CITY OF ALBUQUERQUE

January 8, 2018

RE: Sunset Farms / Puesta Del Sol Subdivision
336 Luis Sanchez Place SW
Request for Permanent C.O. – Not Accepted
Engineer's Stamp Date: 06/23/17
Engineer's Certification Dated: 01/04/18
Hydrology File: K12D025

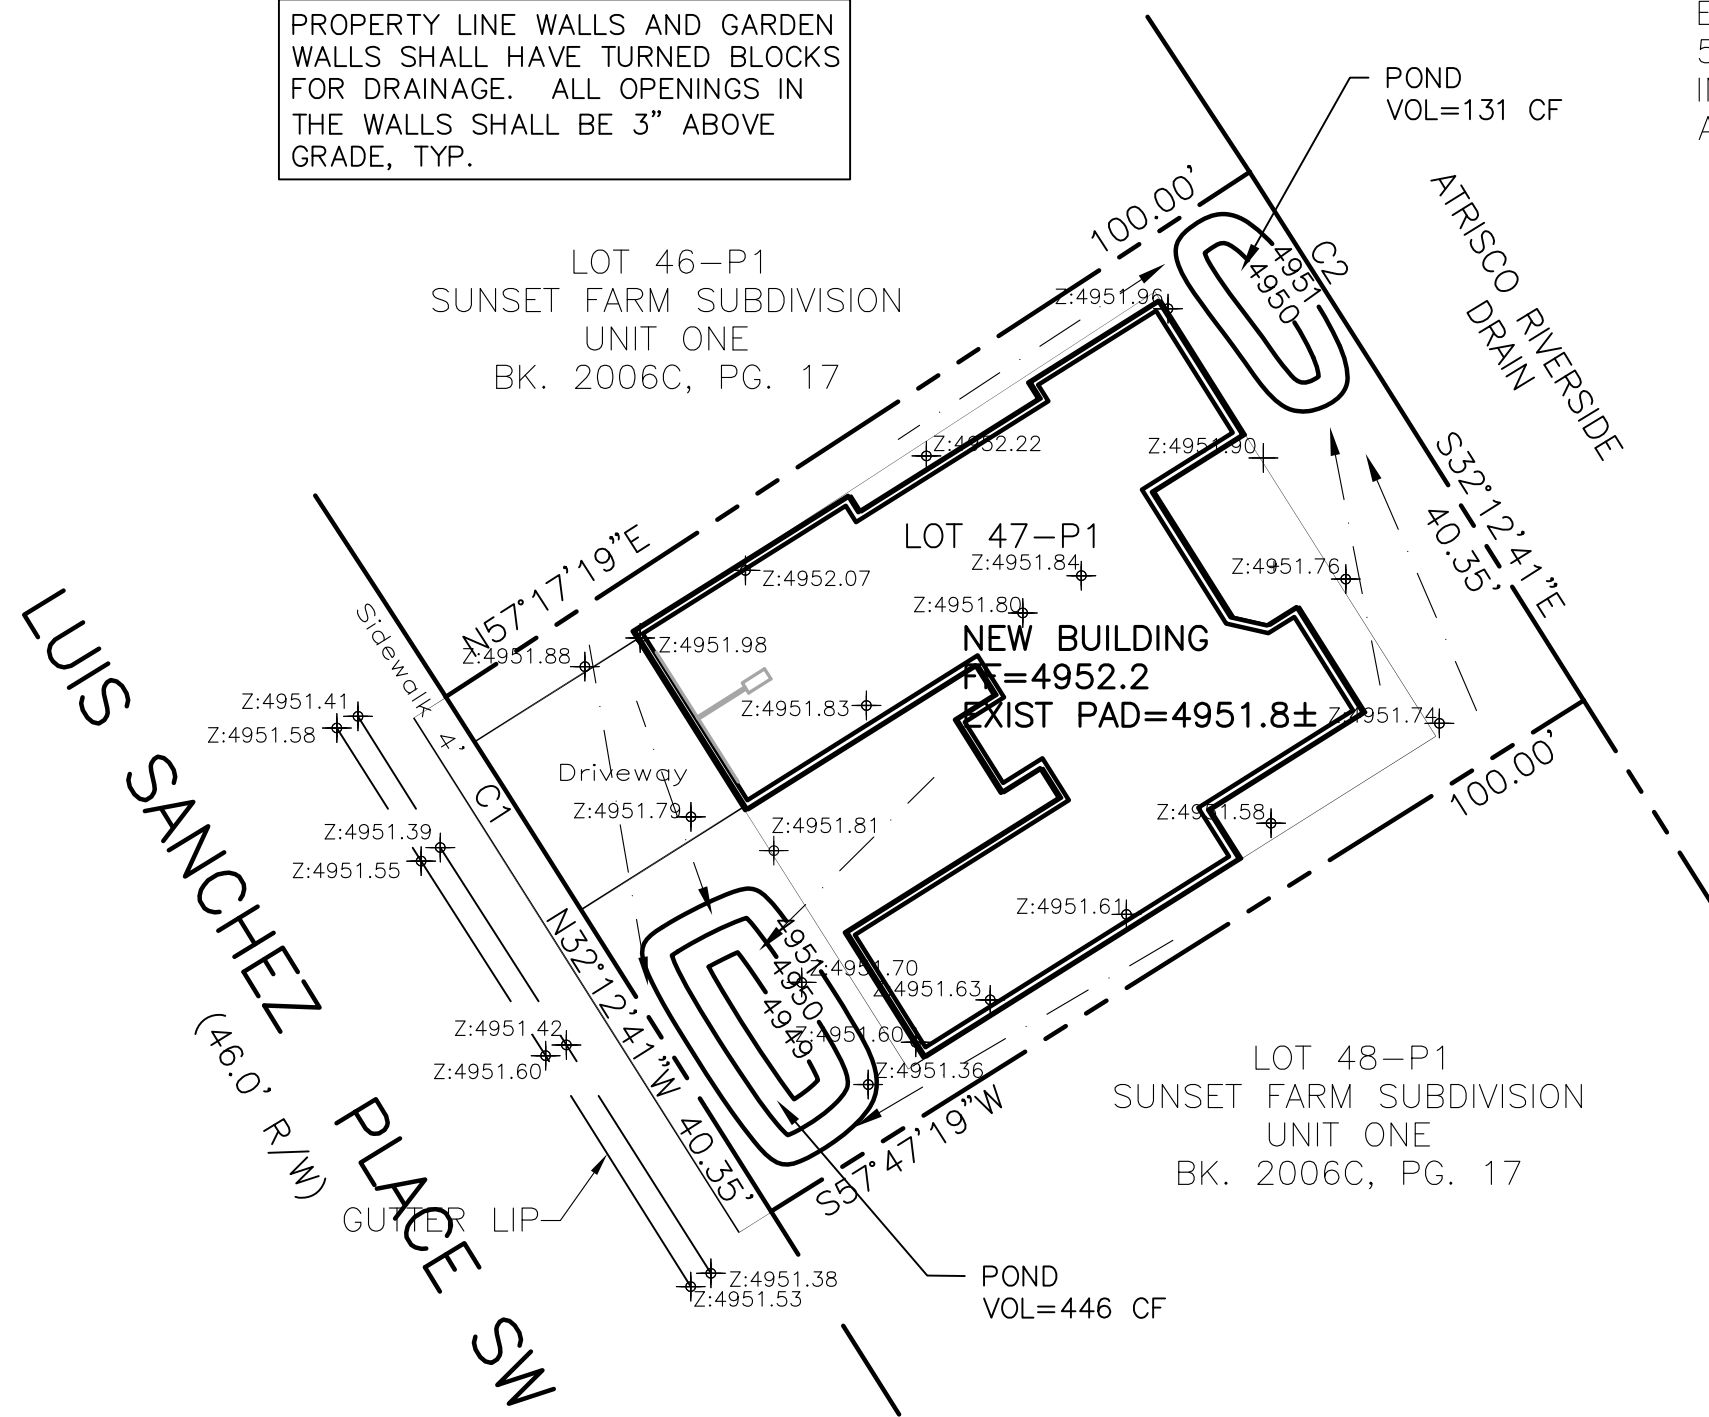
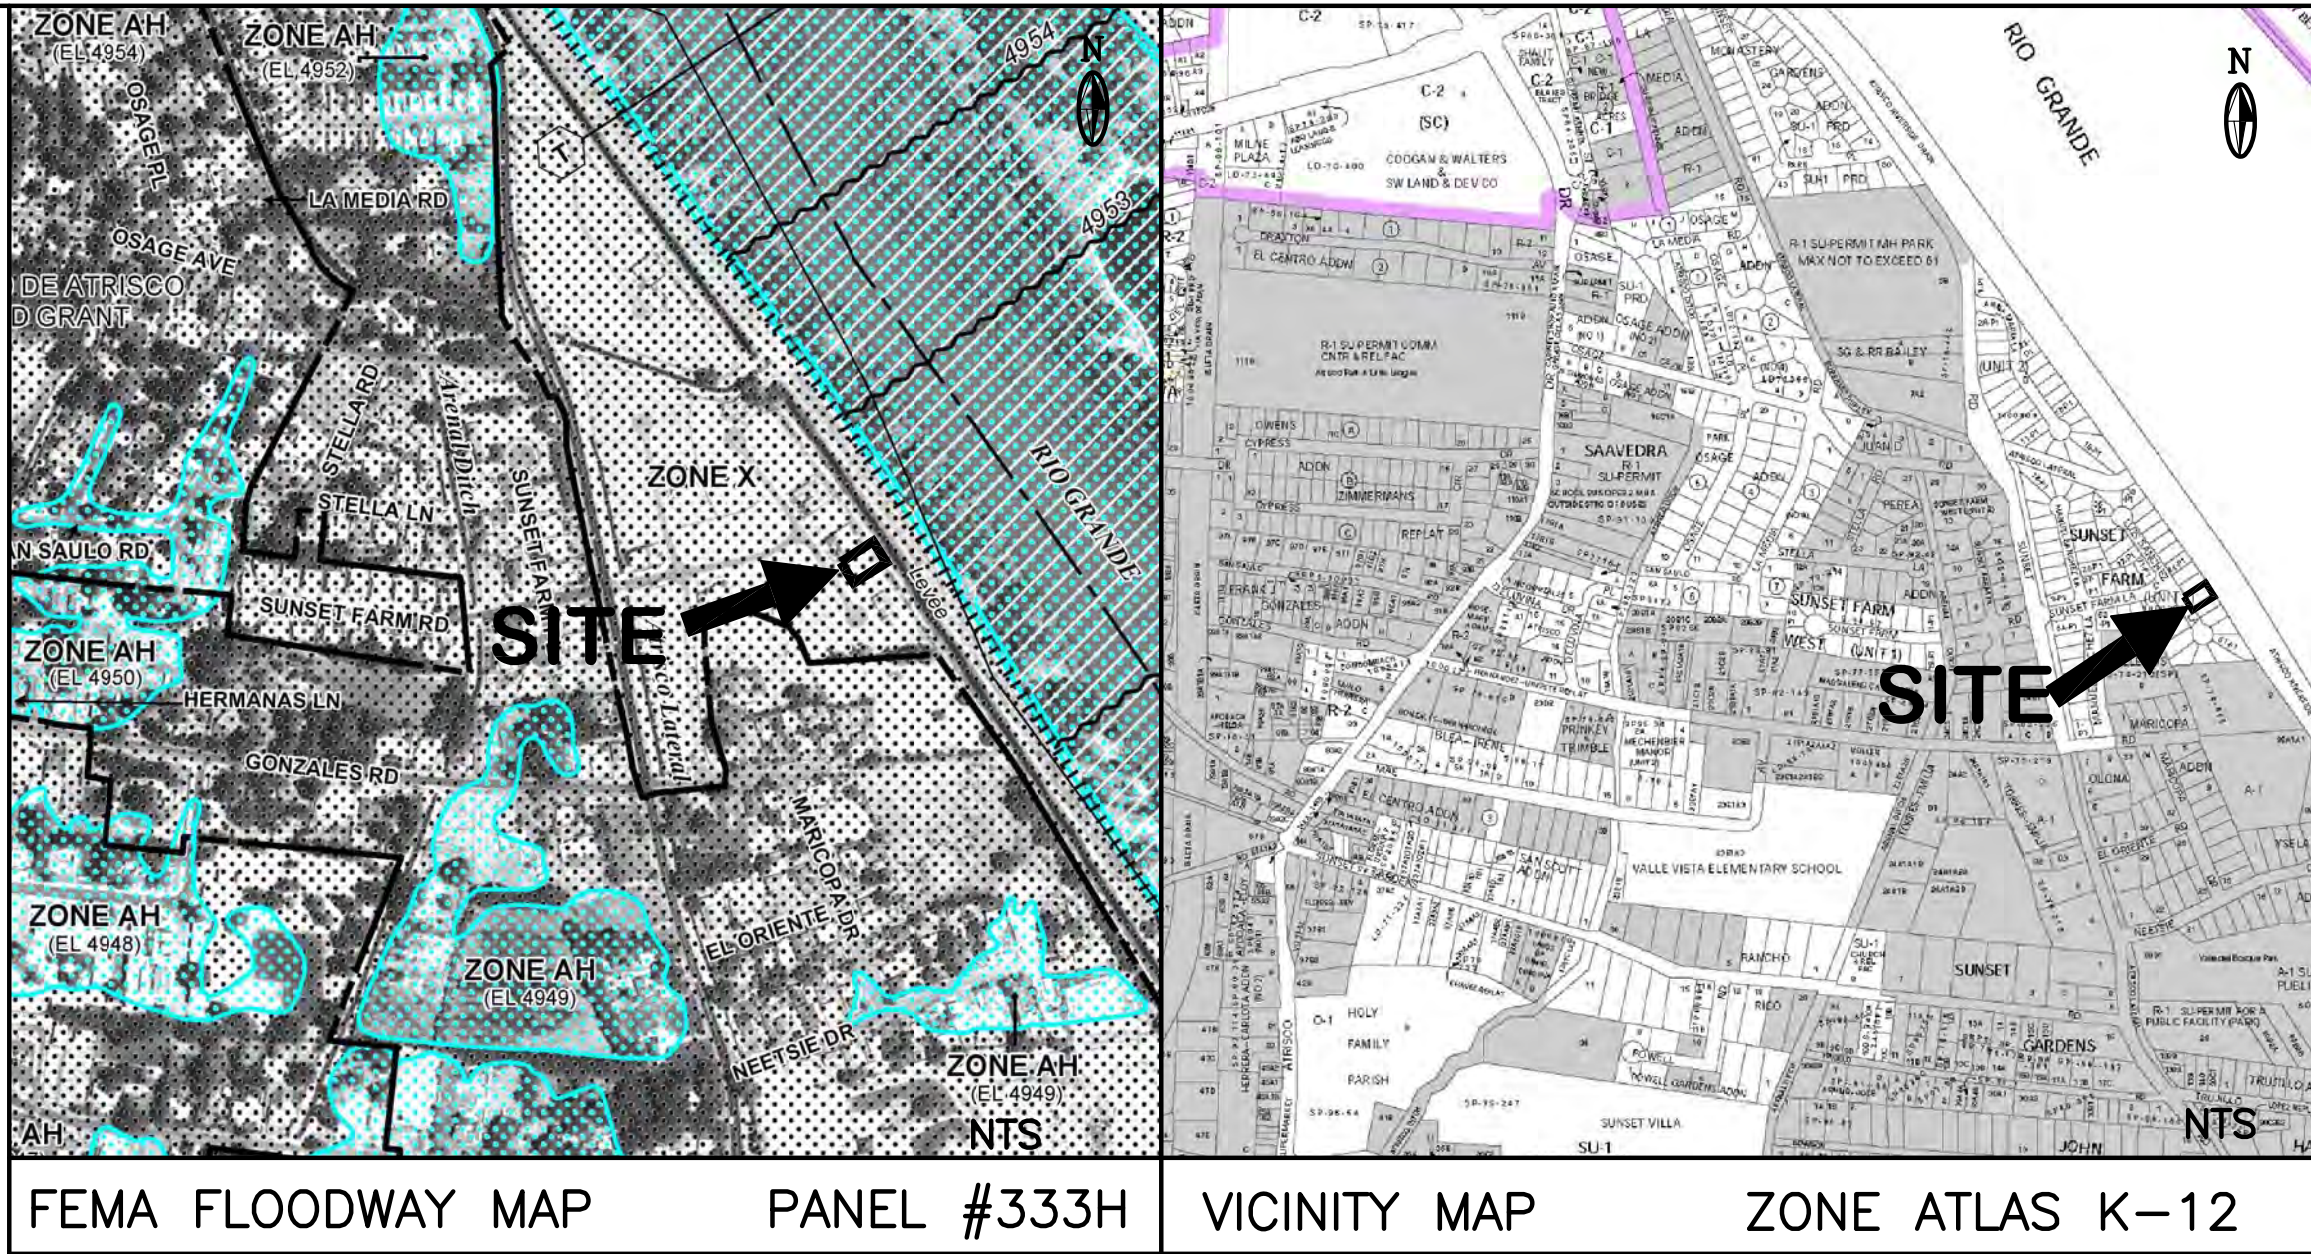
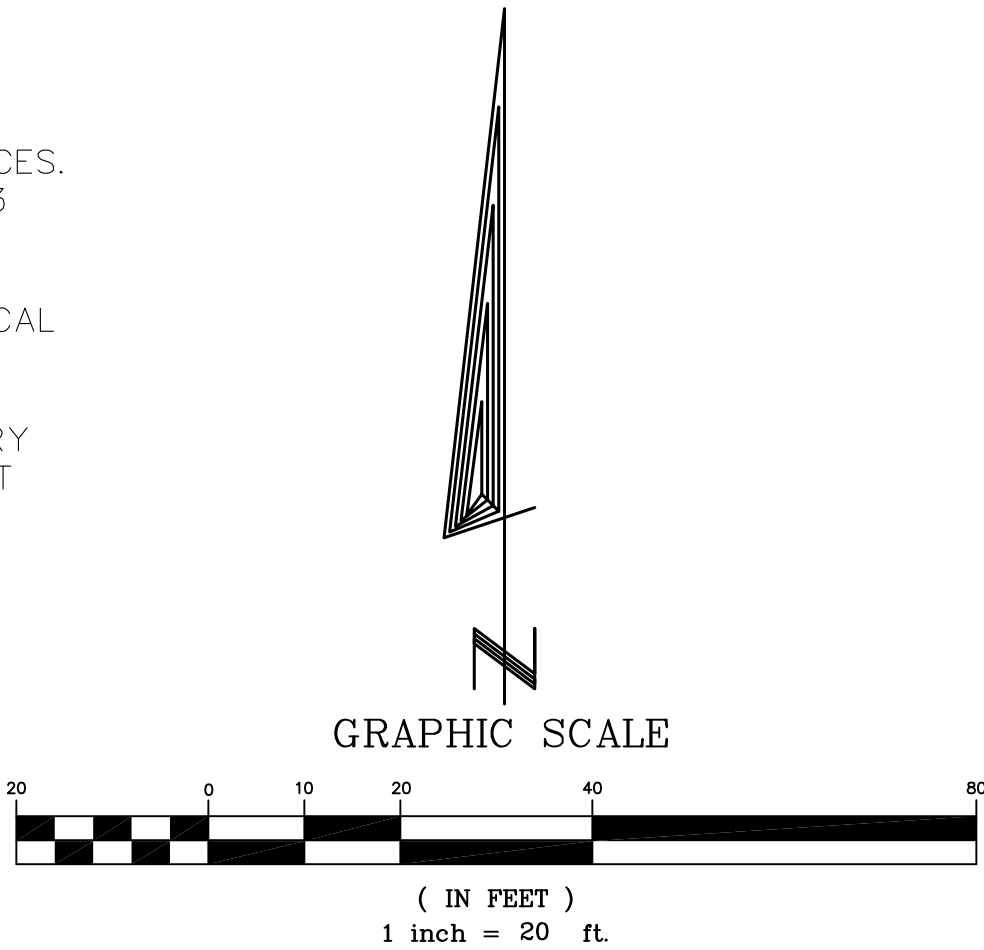
1. The required pond in the rear does not exist (see photo below). Either, this pond needs to be built, or the pond in the front needs to pick up the difference of what was designed and the required 509CF.
